MONA OFFSHORE WIND PROJECT

Mona Change Request Report

Document Reference: S_CR_2

1 November 2024

**Change 1a – Order Limits change to include an existing access track to the west of the onshore substation for temporary access during onshore site preparation works**

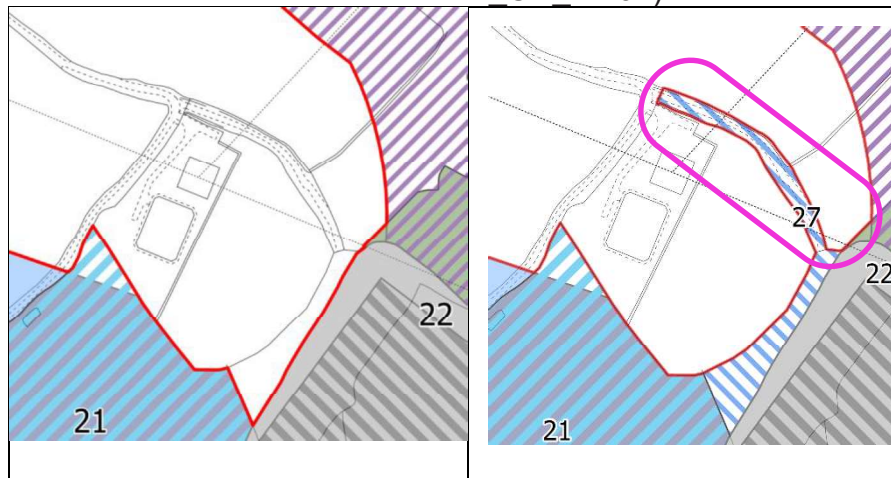
1.2.1.2 This change will result in the inclusion of a section of the existing access track at the onshore substation at grid reference SJ 01353 73277 within the Order Limits to accommodate temporary construction access.

1.2.1.3 This existing access track is currently being utilised by the Applicant for ongoing site survey and investigation works. This change does not involve any works or upgrades to the existing track, the track will only be used to take access to Work Nos. 21, 22 and 31 (and other works areas adjacent to Work Nos. 21, 22 and 31).

- 1.2.1.4 The change results in an extension of the Order Limits from Work No. 22 to the field boundary where the existing access track (subject of Change 1a) terminates at grid reference SJ 01384 73165.

- 1.2.1.5 As shown on the Change Request: Works Plan - Onshore (Document Reference S_CR_4 F01), Changes 1a and 1b will become part of Work No. 27.
- 1.2.1.6 Changes 1a and 1b will allow temporary access to the onshore substation site (including Work Nos. 21-24 and 27, 29, 32, 33, 34 and 36) for vehicles in relation to onshore site preparation works required at and around the substation, prior to the construction and availability of the new onshore substation construction access from Glascoed Road.

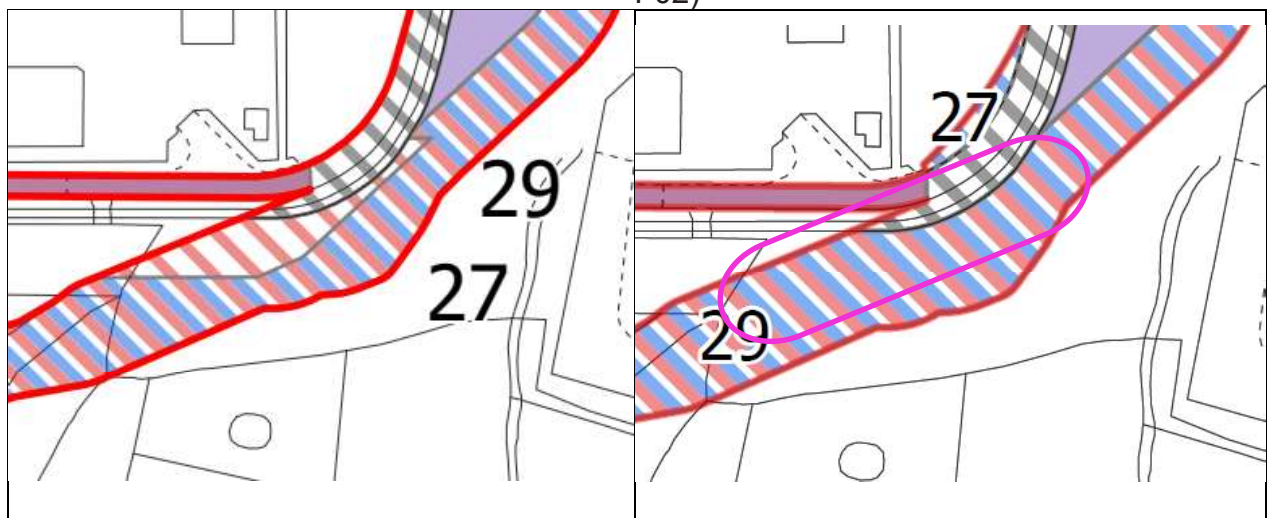
Change 2b – Amendment to Work No. 27 to widen the temporary onshore substation construction access road at grid reference SJ 01911 735518 by including a small area of additional land to the area identified for Work No. 27 (approximately 538m²) within the existing Order Limits. This land is currently identified as part of the permanent onshore substation access (Work No. 29) only.

1.2.2.4 The Applicant’s preliminary design work has identified additional space is needed along the temporary construction access road in this area to facilitate the AIL’s whilst ensuring adequate space for the fencing requirements outlined in the Outline Fencing Management Plan (REP2-048).

**1.2.3 Change 3 – Amendment of the proposed Order Limits to include additional land adjacent to the onshore substation construction access bellmouth to accommodate a temporary construction drainage attenuation basin**

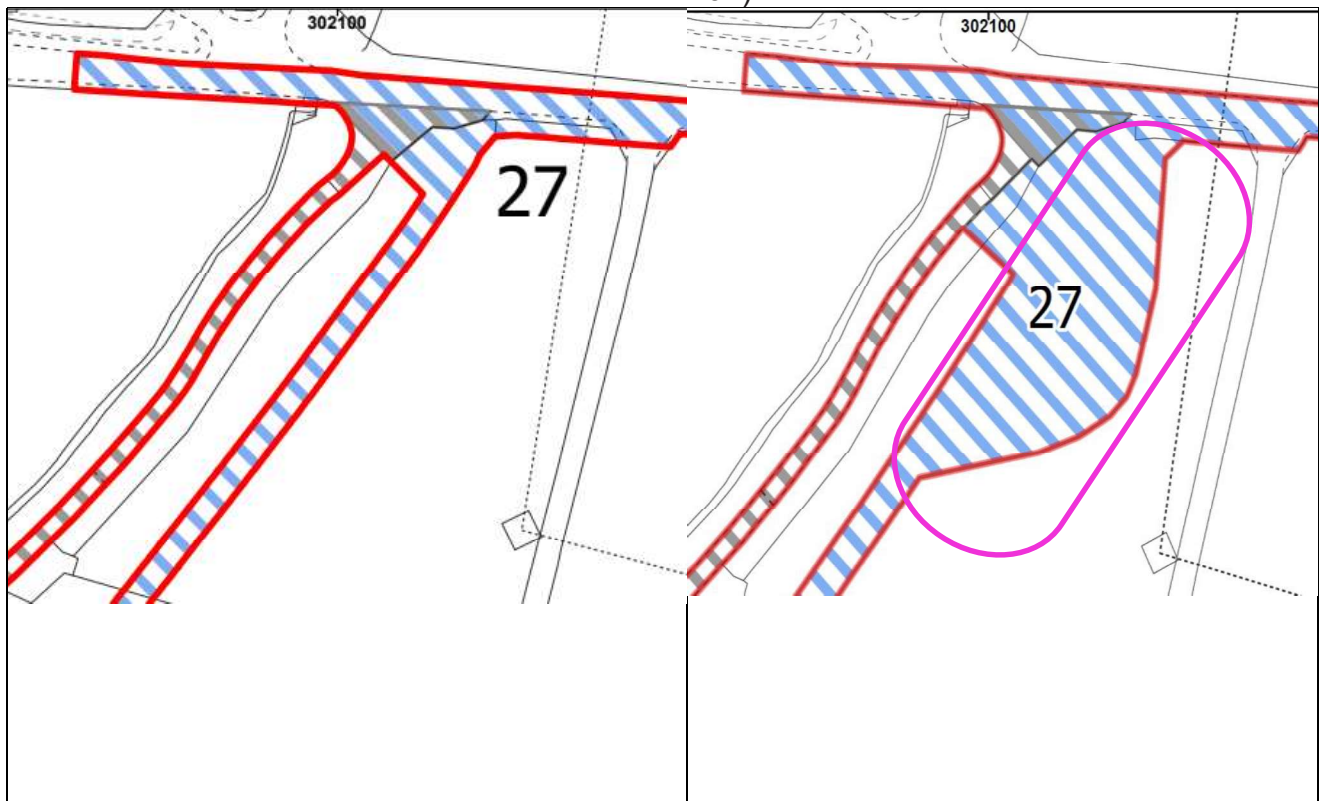
1.2.3.1 This change results in a widened temporary onshore substation construction access road (eastward) to accommodate an additional temporary Sustainable Urban Drainage System (SuDS) attenuation pond at the northern extent of the onshore substation construction access road.

1.2.3.2 The additional area of land required for Change 3 amounts to approximately 2350m². Whilst this land was included within the Mona PEIR Offshore Wind Project Boundary published in April 2023, it was not included upon submission on the basis of the preliminary designs for the onshore substation construction access road. However, the Applicant’s early detailed design works for the onshore substation construction access road, including the swept path analysis outlined in Change 2 (specifically Change 2a), have identified the need for additional land take. This is in order to deliver attenuation to control the discharge of surface water during construction, in part due to the wider road outlined in Change 2a, and also from the requirement for great crested newt fencing to be deployed, likely resulting in additional drainage pathways. It is proposed to construct a temporary SuDS attenuation basin as a measure to control this additional surface water runoff. The proposed Change 3 will result in

a controlled surface water discharge into an existing drainage channel, reducing the risk of increased flooding downstream.

**1.2.4 Change 4 – Amendment and widening of the proposed Order Limits to include an area of land to accommodate an area of hardstanding during the construction period to allow establishment of the permanent access road**

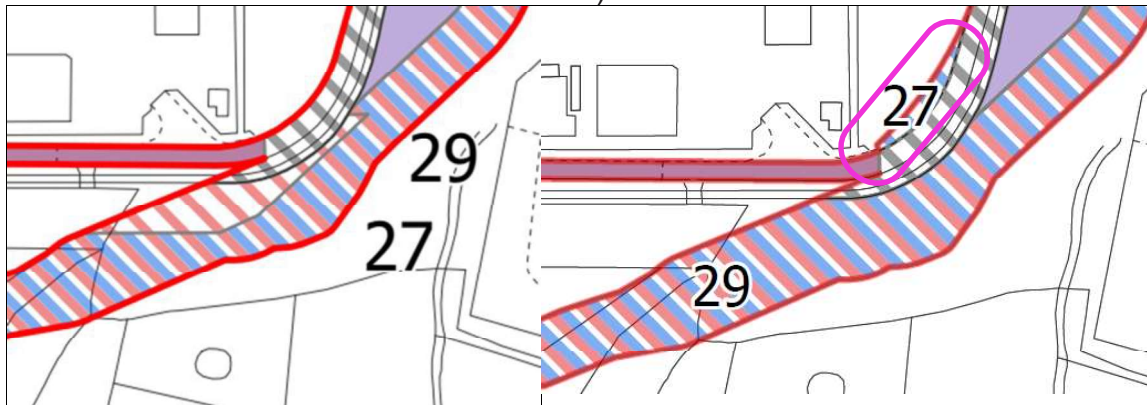
1.2.4.1 This change results in an extension of the Order Limits at grid reference SJ 01935 73551 to include the site of proposed Change 4. Proposed Change 4 will comprise a temporary area of hardstanding to be constructed immediately to the north of the existing road providing access to Bodelwyddan National Grid Substation and Gwynt y Mor Offshore Transmission Operator substation. This hardstanding will be in place during the construction period only and is necessary to facilitate the establishment of the permanent access road (Work No. 29).

1.2.4.2 In providing this temporary hardstanding, disruption to the users of the existing road will be reduced by removing the need to temporarily close the road for construction purposes.
